WEST SUSSEX COUNTY COUNCIL CONSULTATION

TO:	<u>Arun</u> District Council <u>FAO:</u> Mr S Davis
FROM:	<u>WSCC</u> - Highways Authority
DATE:	27 June 2019
LOCATION:	The Cottage <u>Shripney</u> Road <u>Bognor</u> Regis <u>PO22 9PA</u>
SUBJECT:	BE/69/19/OUT Outline planning application with all matters reserved except access for 31 No. houses and flats with car parking, landscaping and associated infrastructure & access off Shripney Road (A29), all following the demolition of the existing dwelling & outbuildings - This application is a Departure from the Development Plan
DATE OF SITE VISIT:	N/A
RECOMMENDATION:	No Objection
<u>S106</u> CONTRIBUTION TOTAL:	£

Proposed Access Drawing 160818-07B

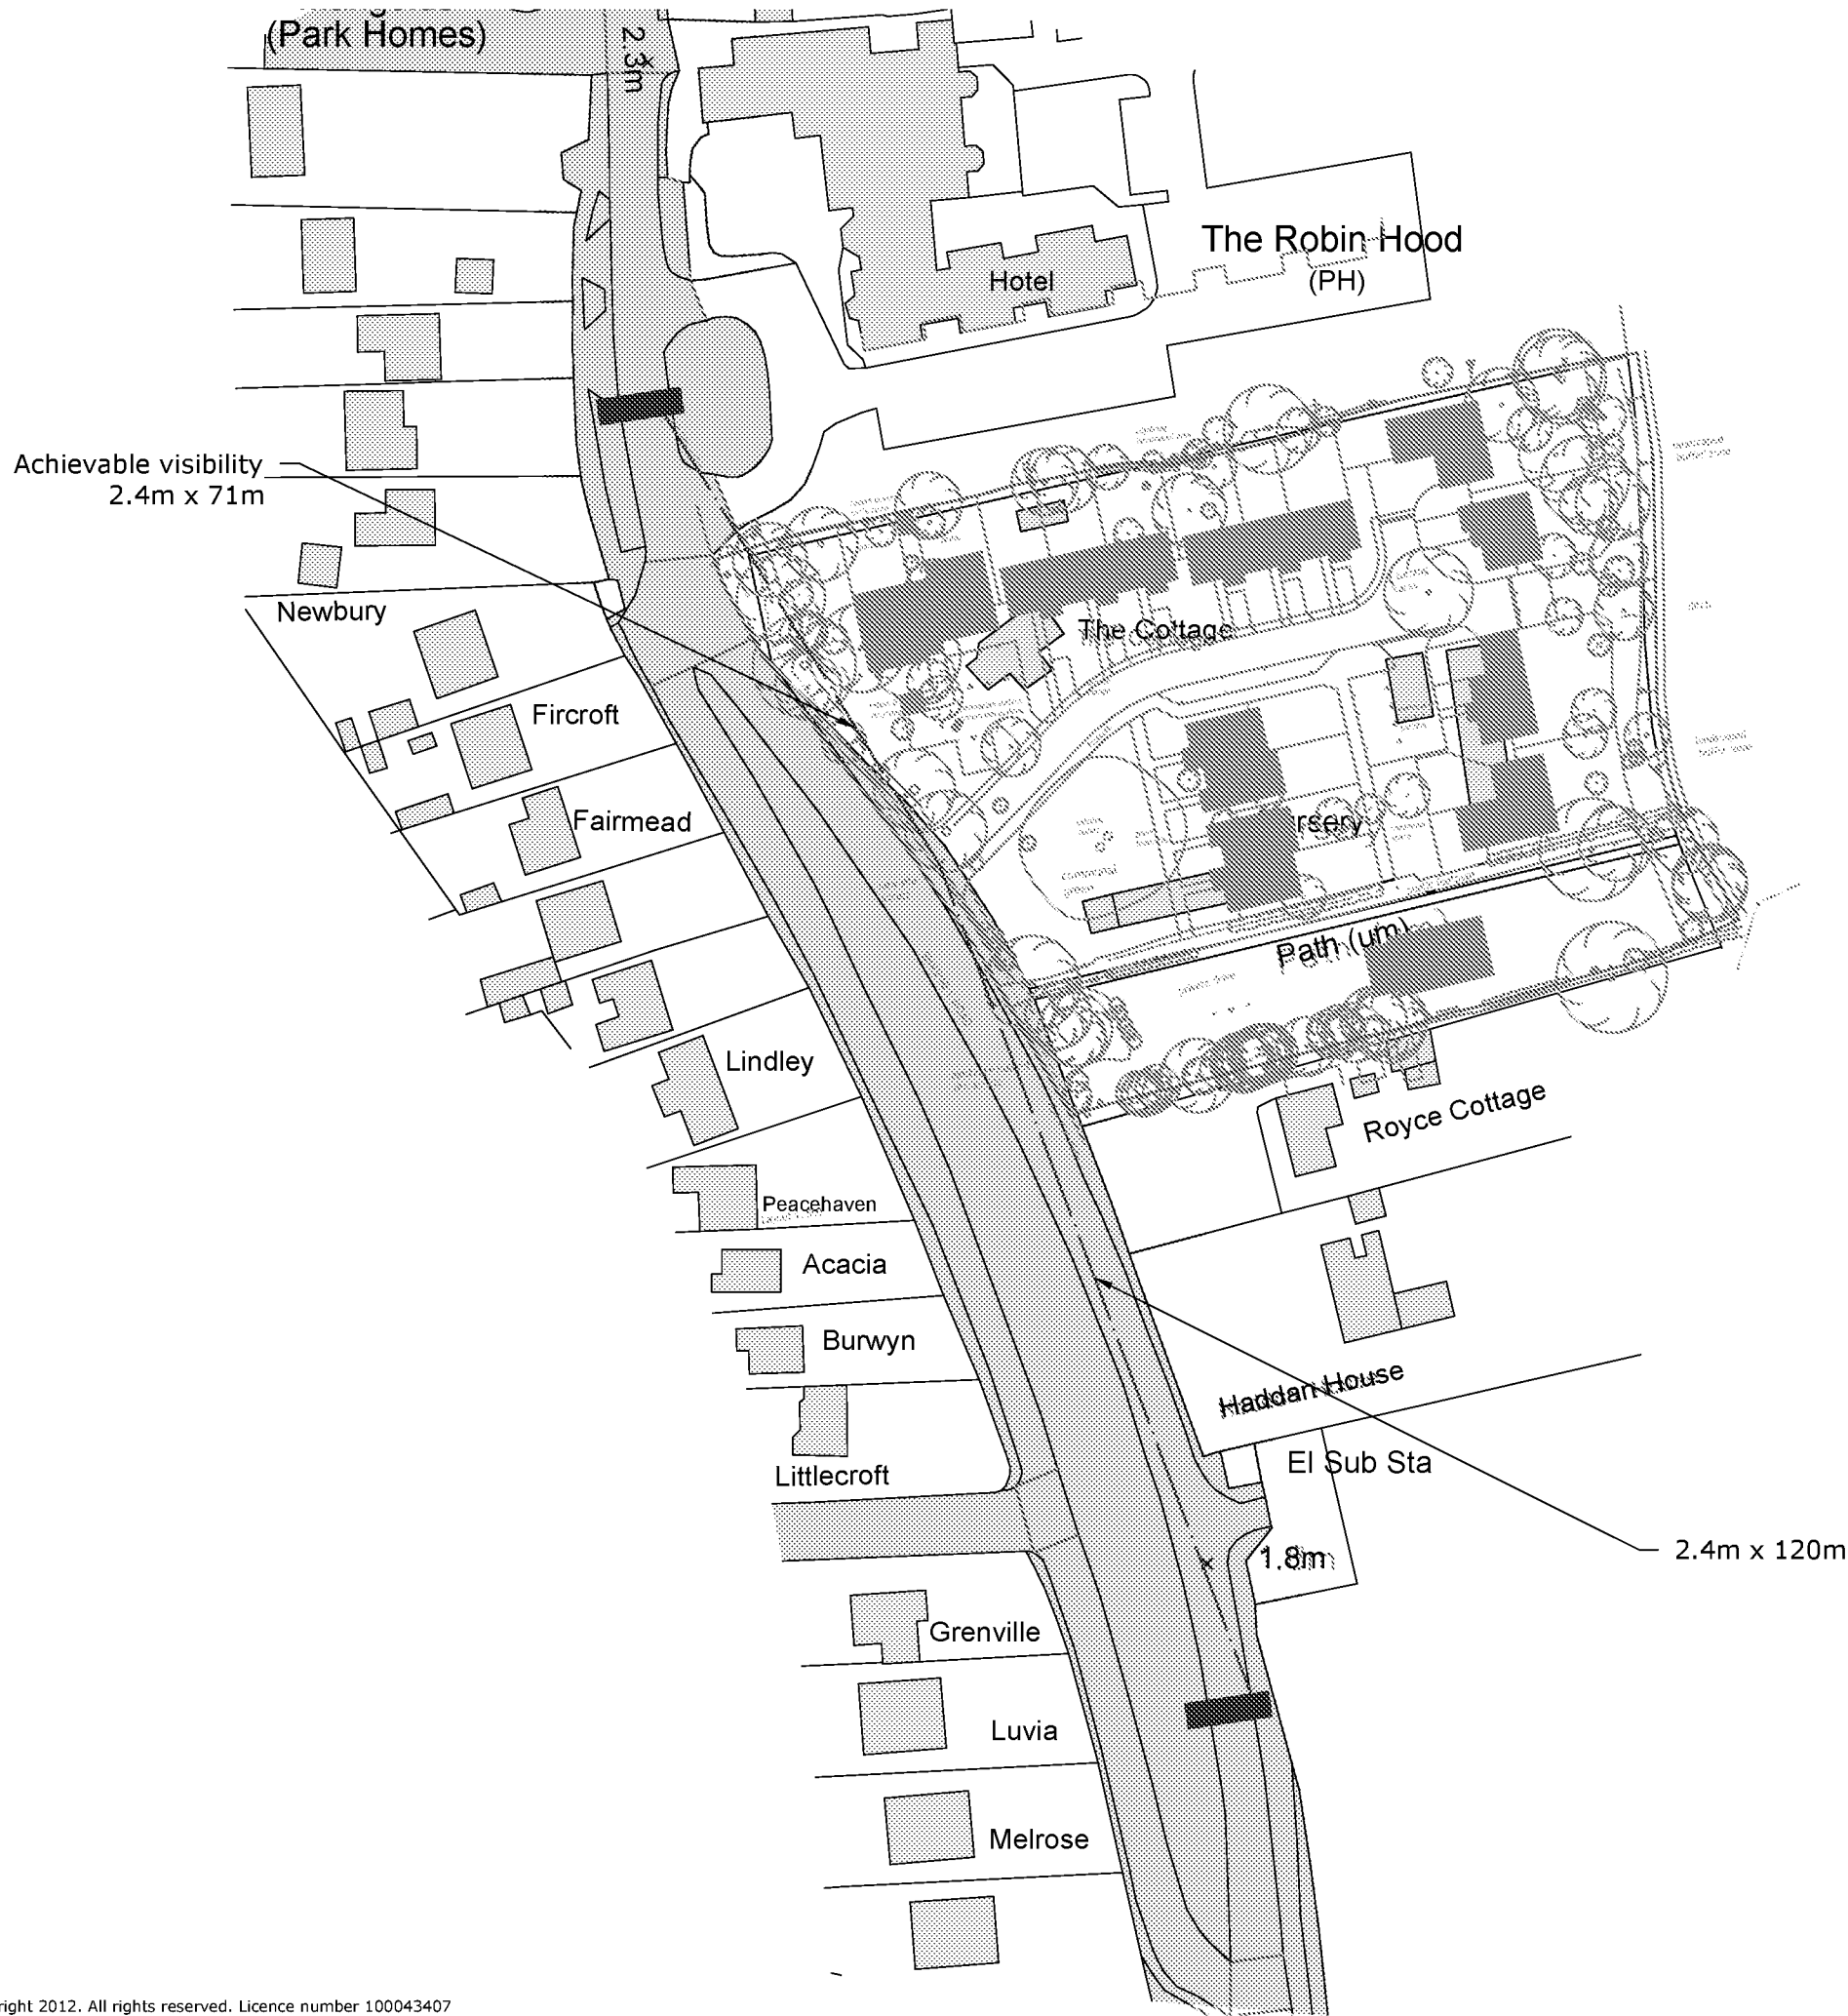
This site was granted planning consent in 2018 for 21 dwellings. This new application is for 31 dwellings using the exact same access set up as the previous application. The uplift of 11 dwellings is estimated to generate an extra 2 two way vehicle trips in the AM peak hour and 6 in the PM peak hour. This level of trips would not raise concern. The Local Highway Authority does not consider that the proposal for an extra 11 dwellings would have an unacceptable impact on highway safety or result in 'severe' cumulative impacts on the operation of the highway network, therefore is not contrary to the National Planning Policy Framework (paragraph 109), and that there are no transport grounds to resist the proposal. The following conditions should be applied to any grant of planning consent.

- *Access* - No development shall commence until the vehicular access serving the proposed site has been constructed in accordance with the approved planning drawing.

No part of the development shall be first occupied until visibility splays of 2.4 metres by 120 metres to the south and 2.4 metres by 71 metres to the north have been provided at the proposed site vehicular access onto Shripney Road, in accordance with the approved planning drawings. Once provided the splays shall thereafter be maintained and kept free of all obstructions over a height of 0.6 metre above adjoining carriageway level.

- *Safety Audit Recommendations* - No development shall commence until such time as revised plans and details incorporating the recommendations given in the Stage 1 Road

Safety Audit and accepted in the Designers Response have been submitted to and approved in writing by the Local Planning Authority in consultation with the Highway Authority.
